# V1Final Plat Drawings.pdf Markup Summary

SHEET 1 OF 5
COVER

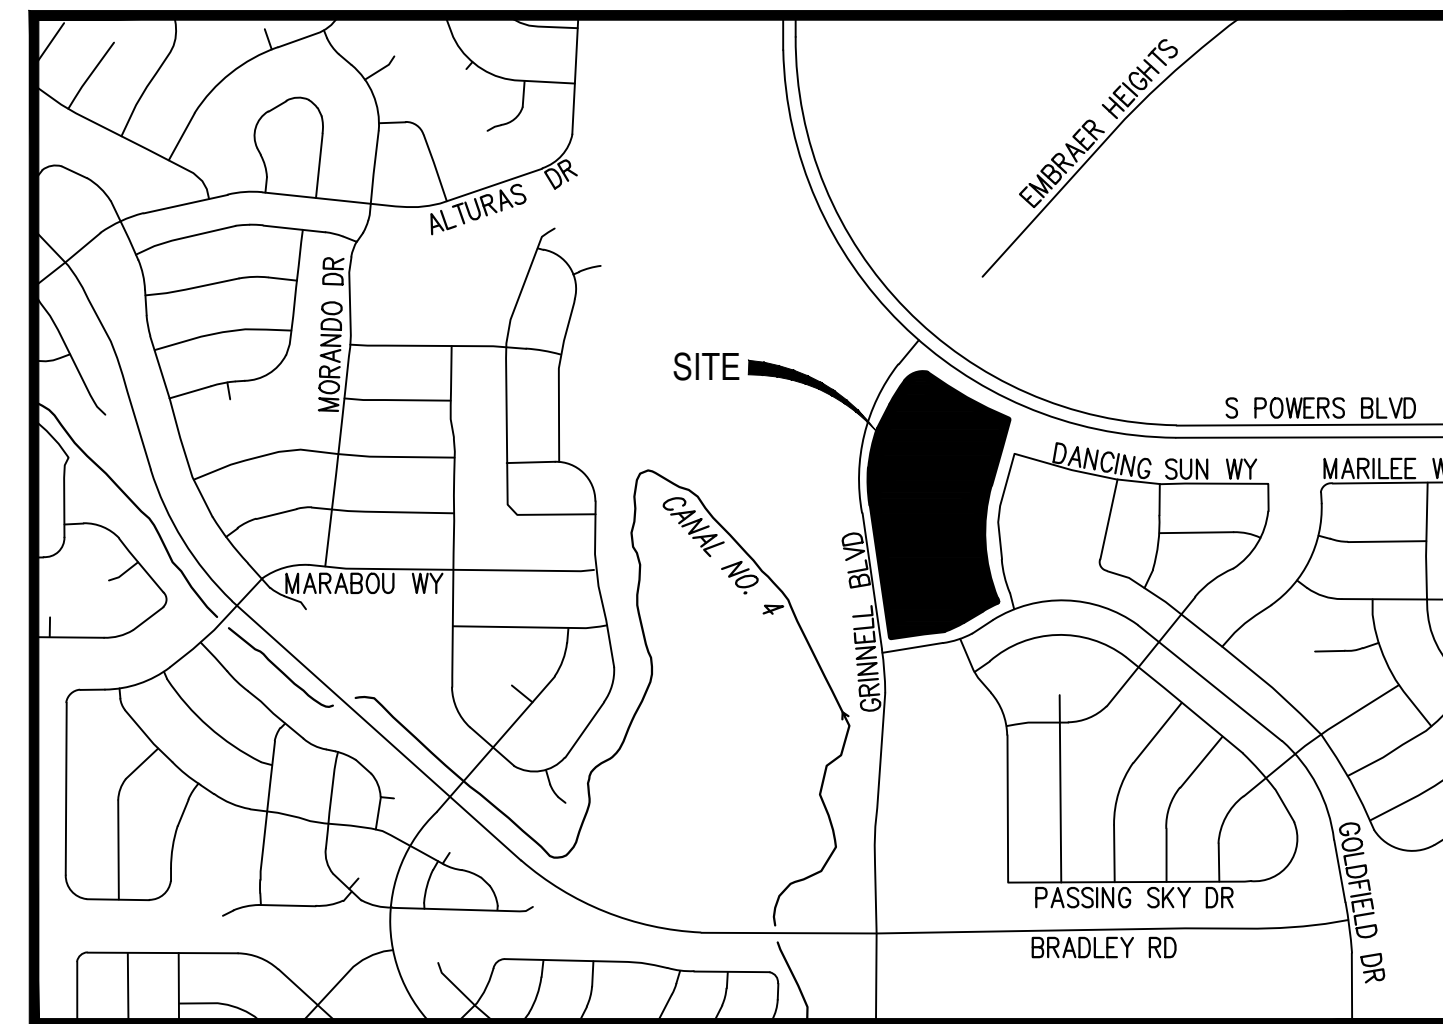
Add "PCD File No. SF2318"

Include note for all Fees to be paid

SITUATED IN THE SOUTHWEST QUARTER OF SECTION 6 AND THE NORTHWEST 1/4 OF SECTION 7, TOWNSHIP 15 SOUTH, RANGE 65 WEST OF THE 6TH P.M.,
 COUNTY OF EL PASO, STATE OF COLORADO
 SHEET 3 OF 5
 EXISTING CONDITIONS

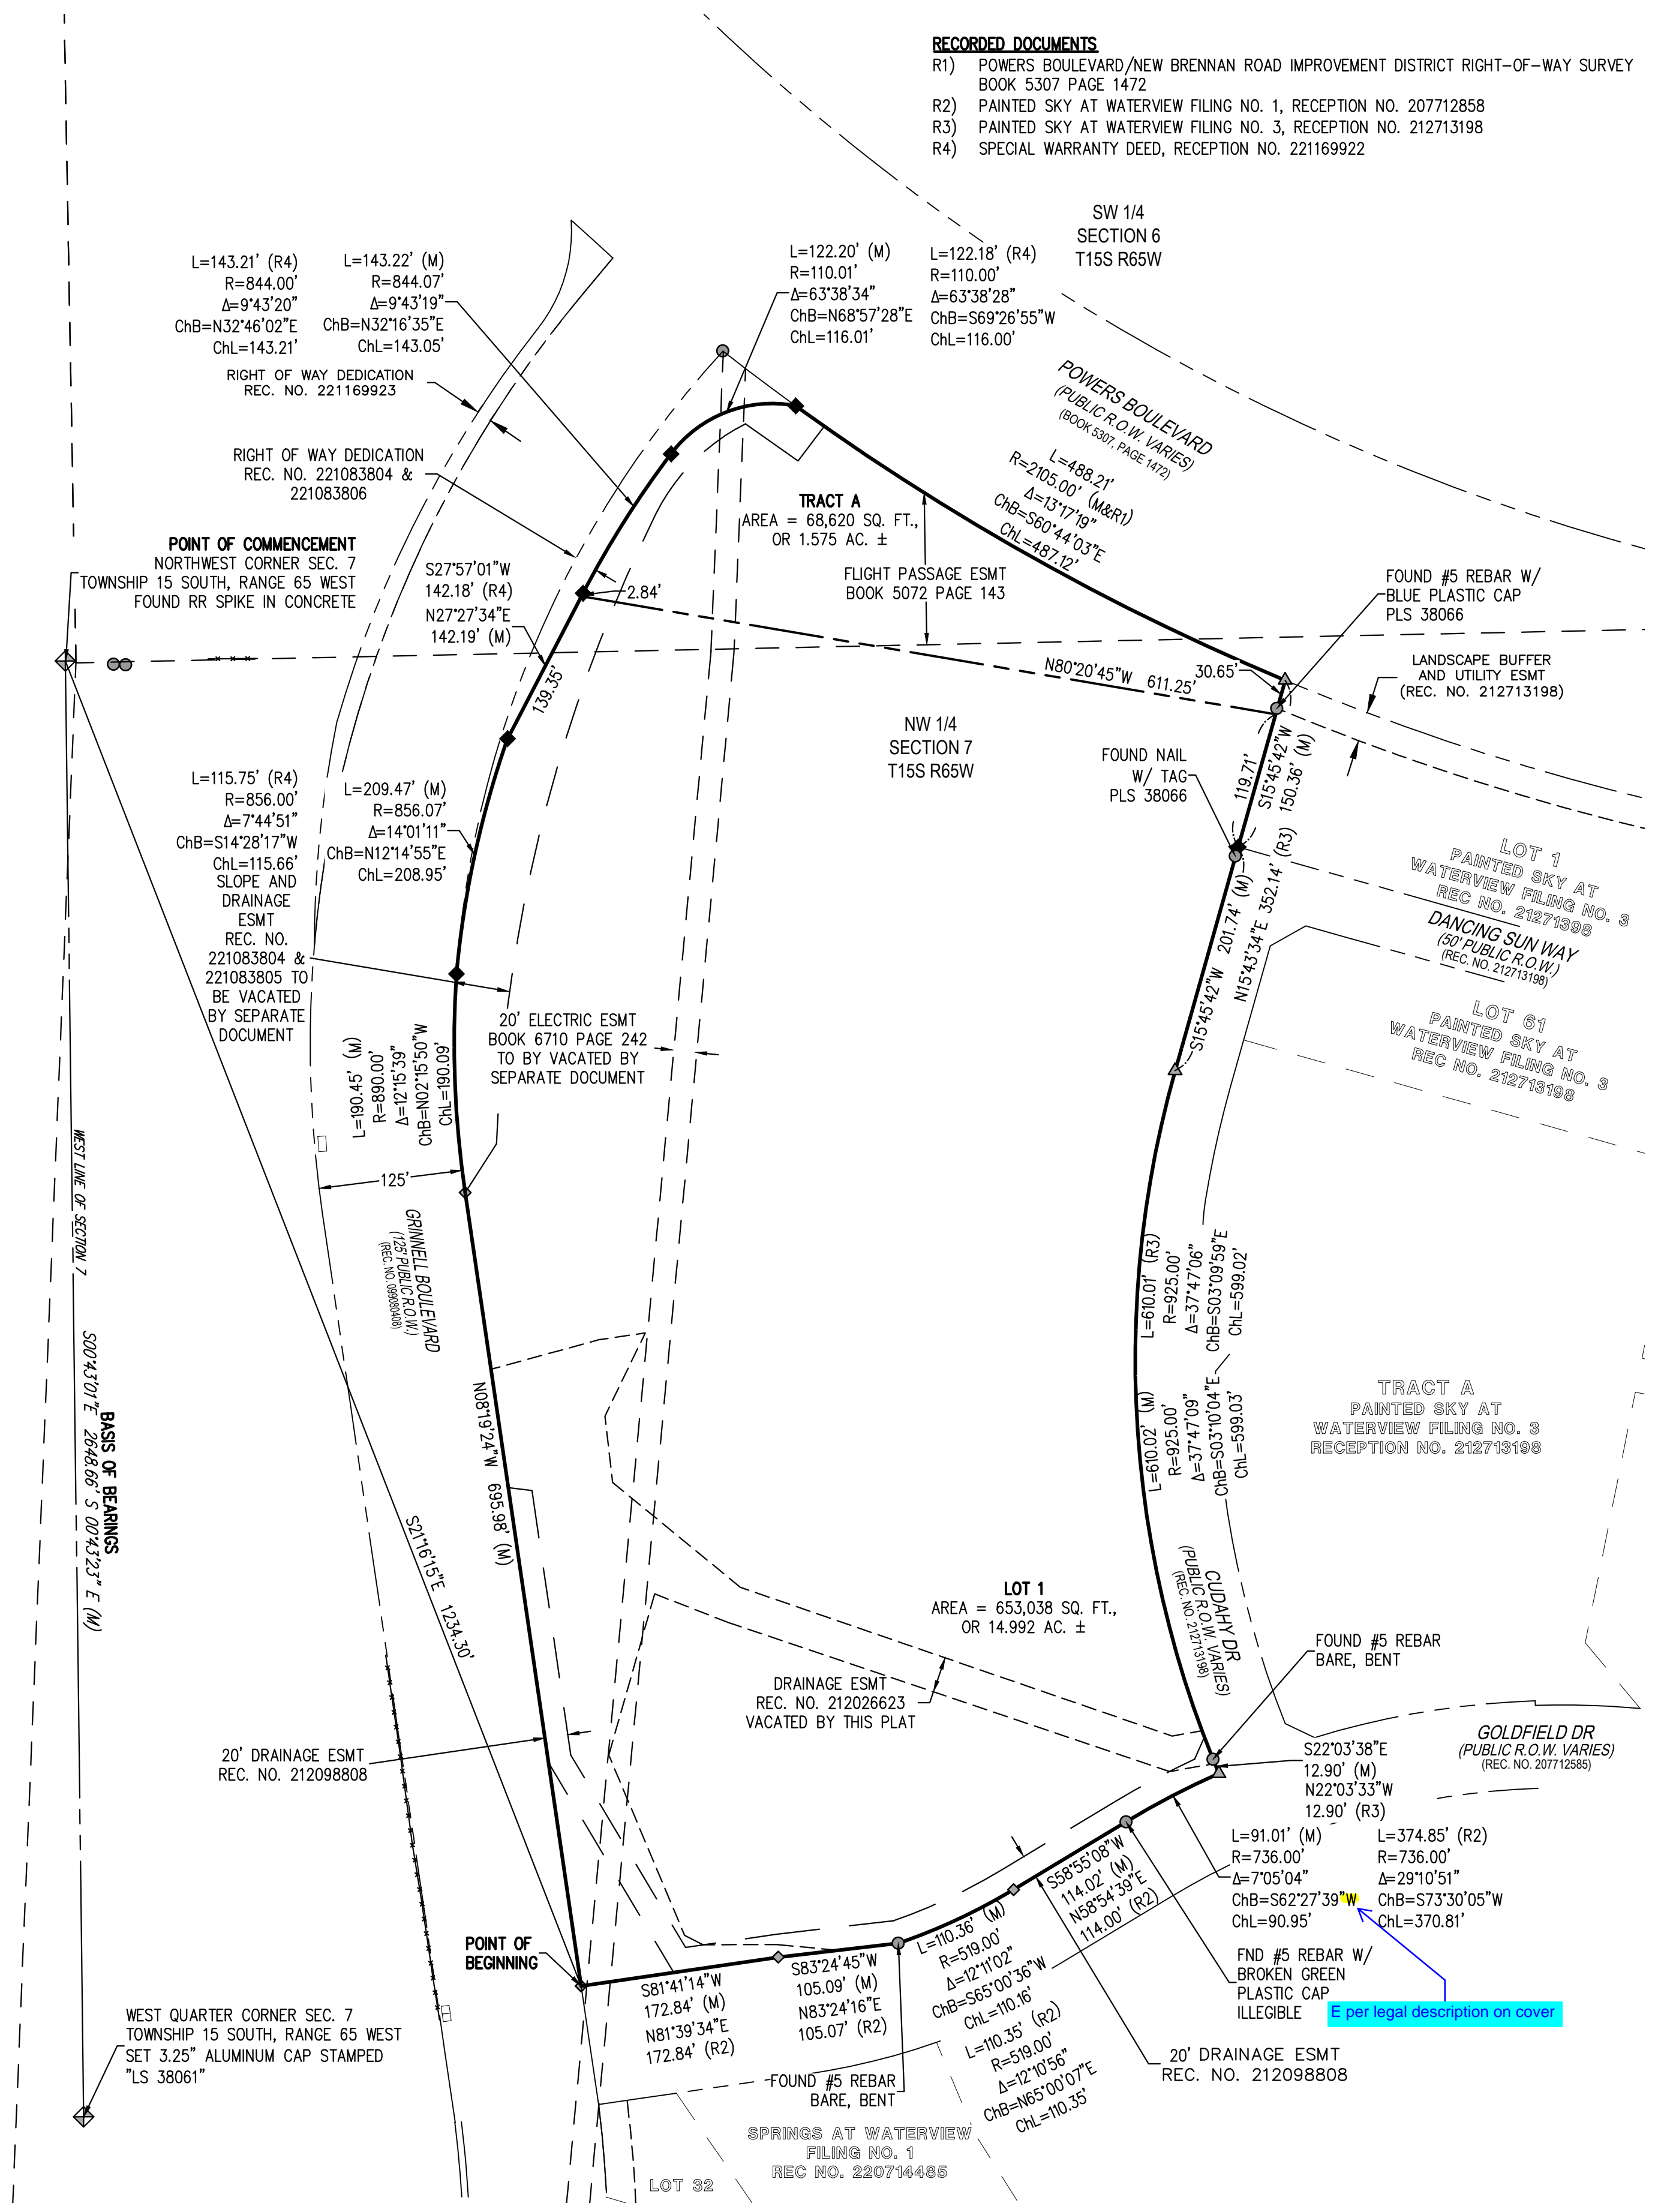
E per legal description on cover
